WEST SUSSEX COUNTY COUNCIL CONSULTATION

TO:	Arun District Council FAO: Andrew Wood
FROM:	WSCC - Highways Authority
DATE:	25 March 2019
LOCATION:	3 The Hard, Elmer, Bognor Regis, PO22 6JS
SUBJECT:	M/24/19/PL Replacement residential dwelling.
DATE OF SITE VISIT:	N/A
RECOMMENDATION:	Advice
S106 CONTRIBUTION TOTAL:	£N/A

PROPOSED FIRST FLOOR PLAN 1:50

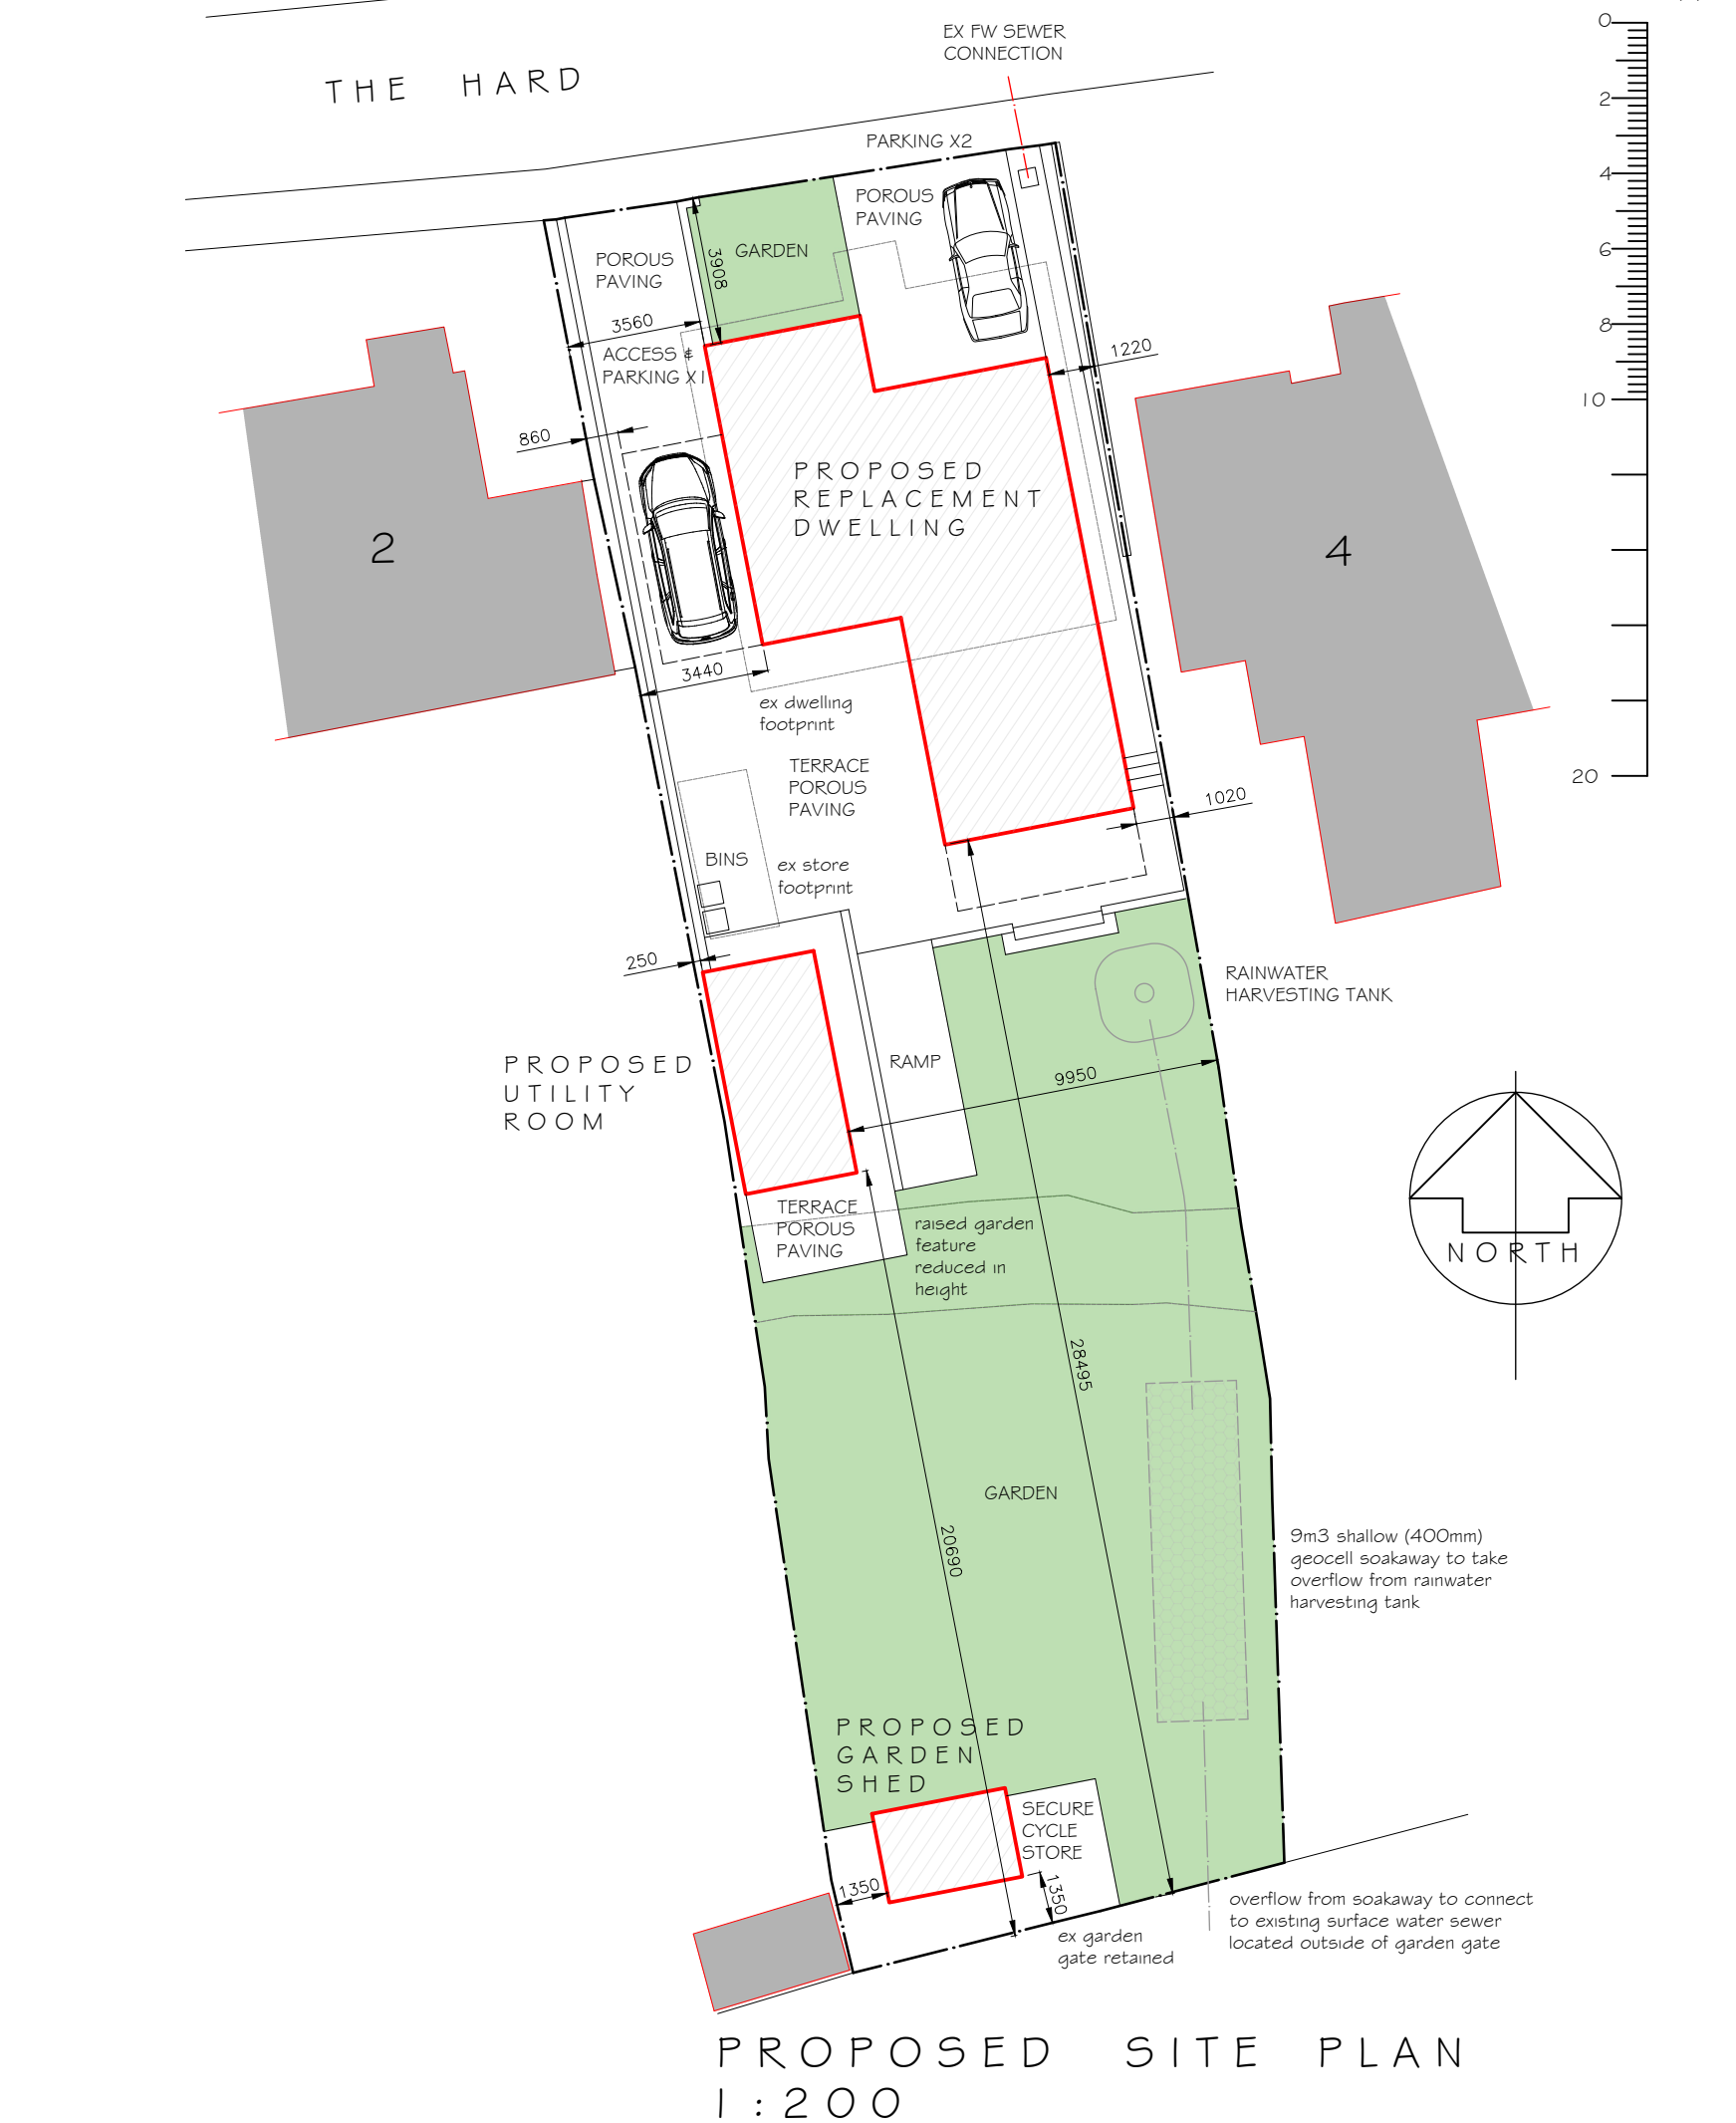
The site is located on The Hard, a privately maintained road subject to a speed limit of 20 mph. The driveway to the west is an existing access, and a second access to the north is planned to allow for 2 more cars to park.

3 car parking spaces are proposed for the replacement dwelling, one more than the existing property. The WSCC Car Parking Demand Calculator indicated the the proposed dwelling would create a demand for 3 car parking spaces. Therefore the proposed number of spaces sufficiently meets the demand. Turning on-site is not achievable, so vehicles entering of exiting the site would have to do so in a reverse gear.

Cycling is a viable mode of transport in the area and a suitable alternative to the use of private car. Cycle storage should be demonstrated in the plans to improve sustainability and allow an alternative transport options.
